Preferred Project Report

Thomas Street Building

University of Technology Sydney

Project Application No. 09_0213

**WEST (JONES STREET)
ELEVATION**

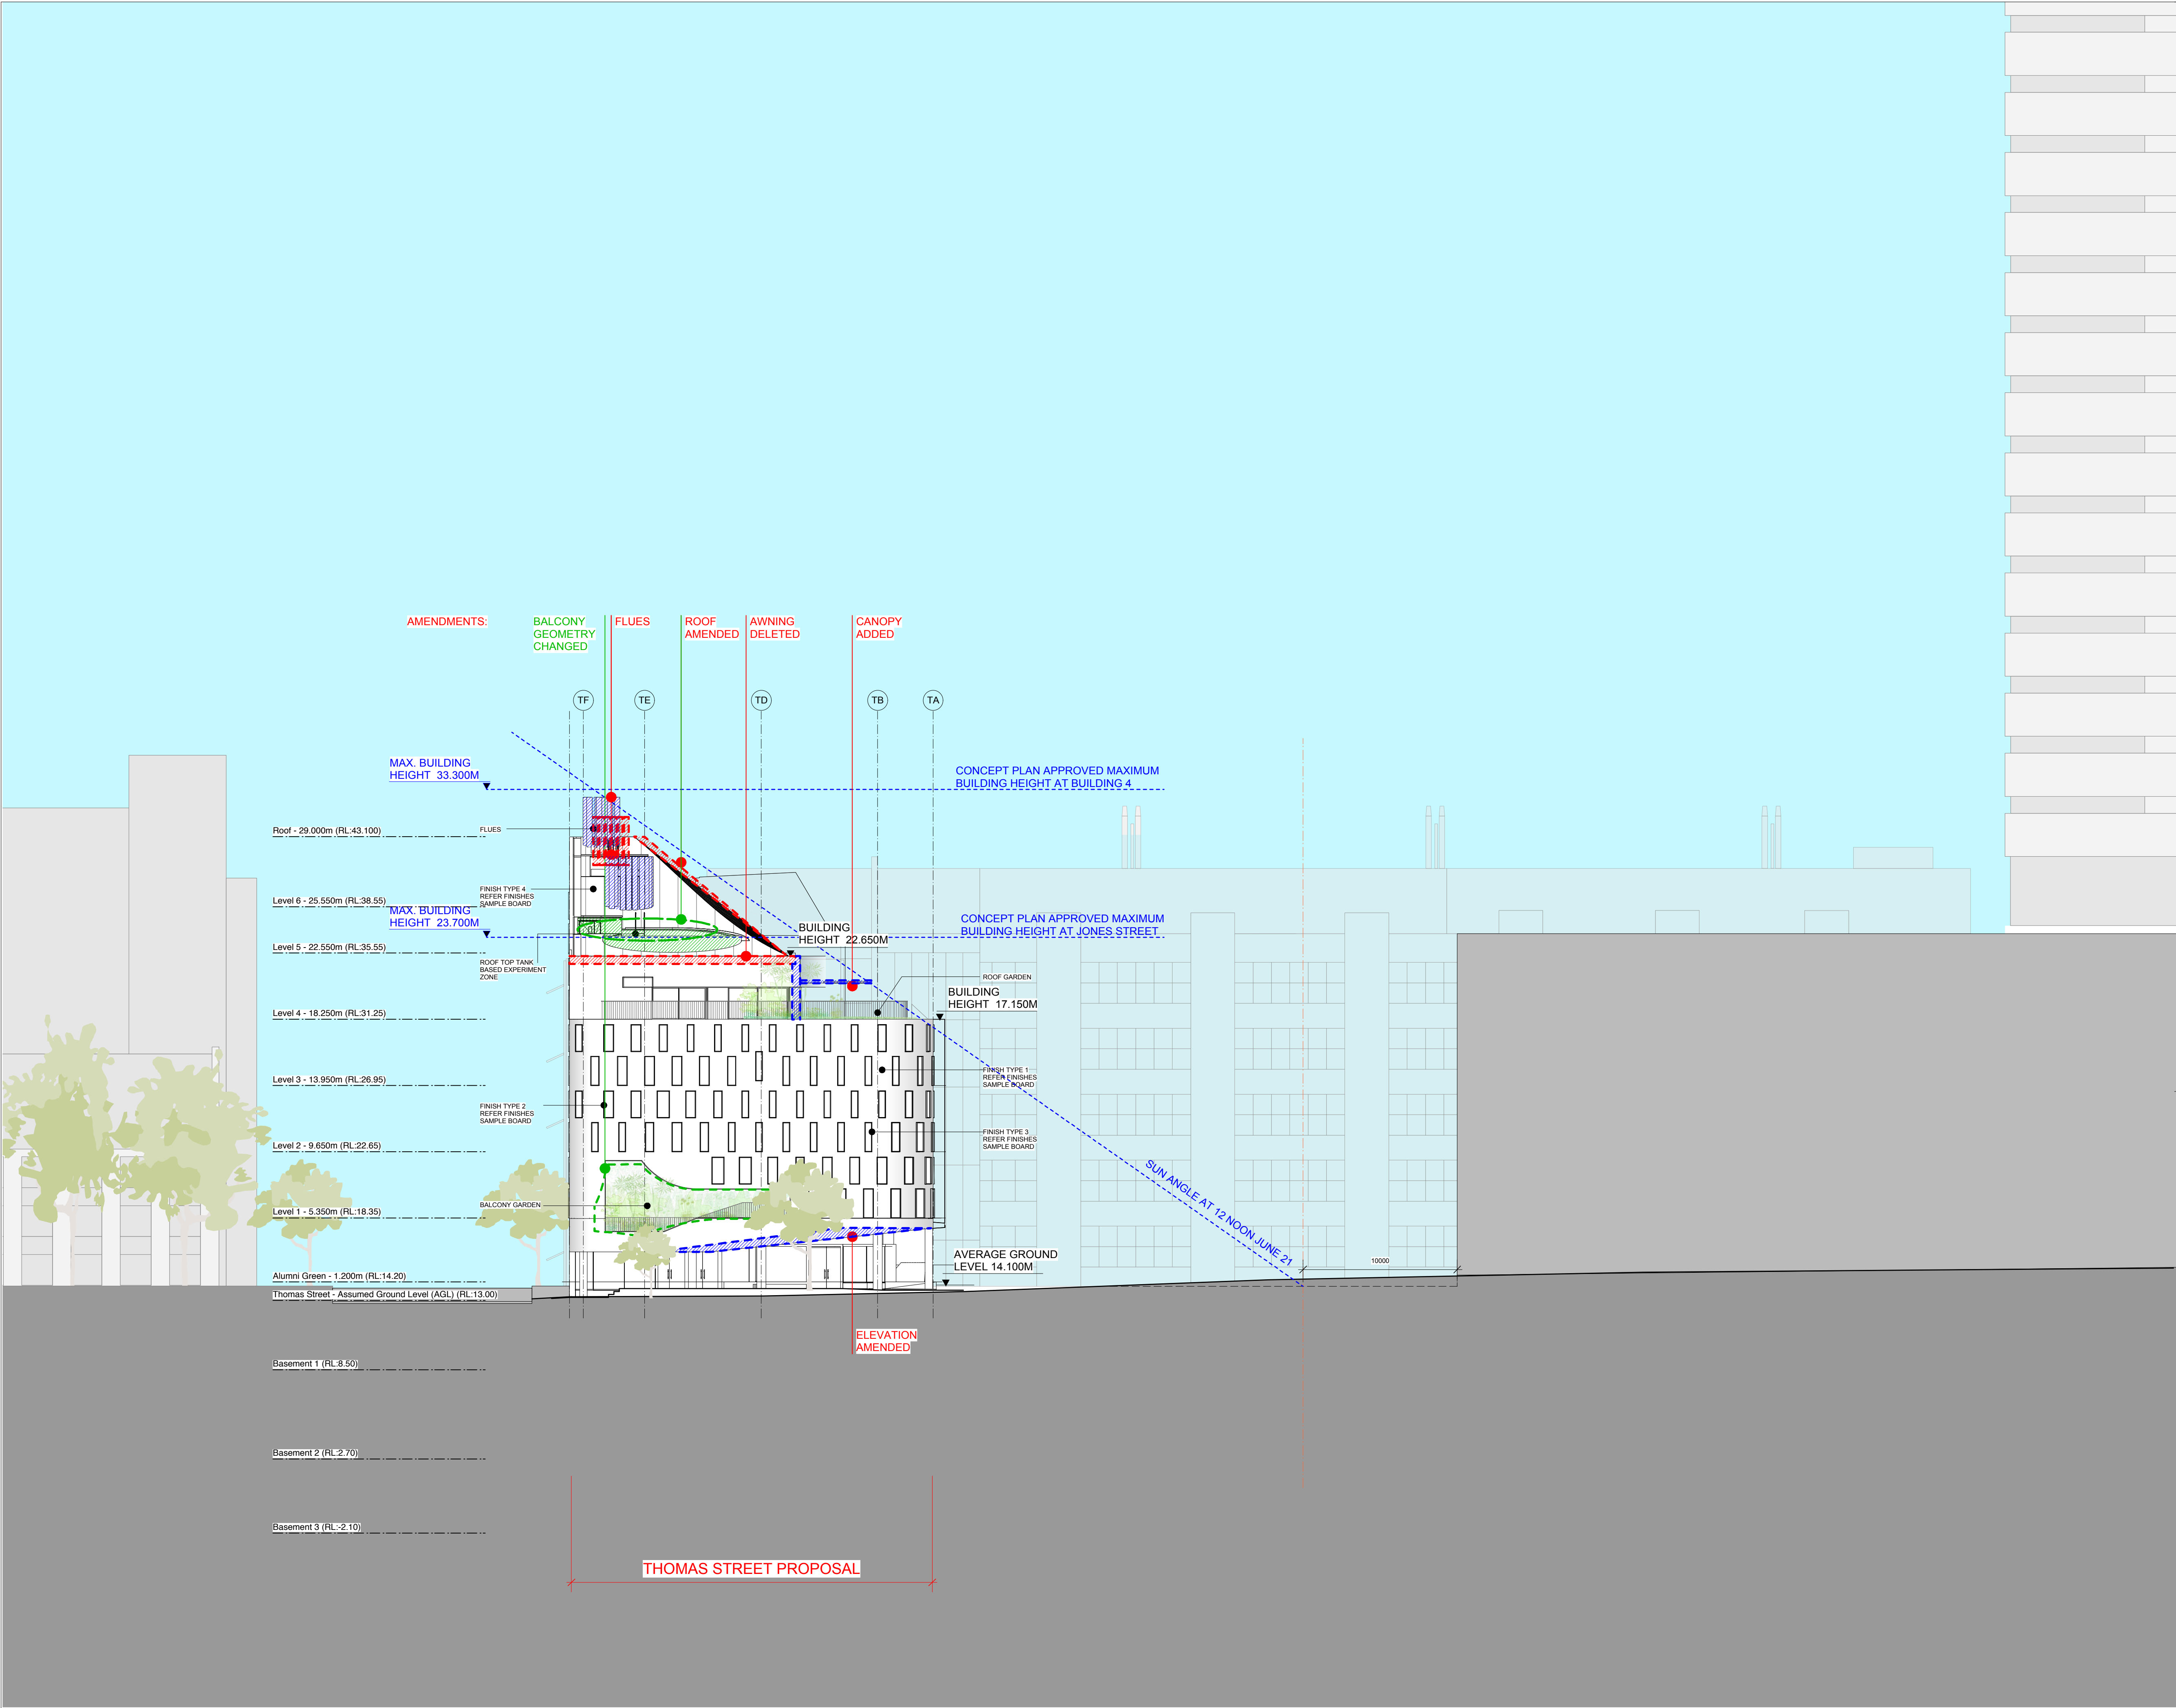
To ensure consistency between plans, the West Elevation Plan has also been amended to reflect the minor adjustment to the change in levels and ramp arrangement. This revised plan is also included at **Attachment 1**.
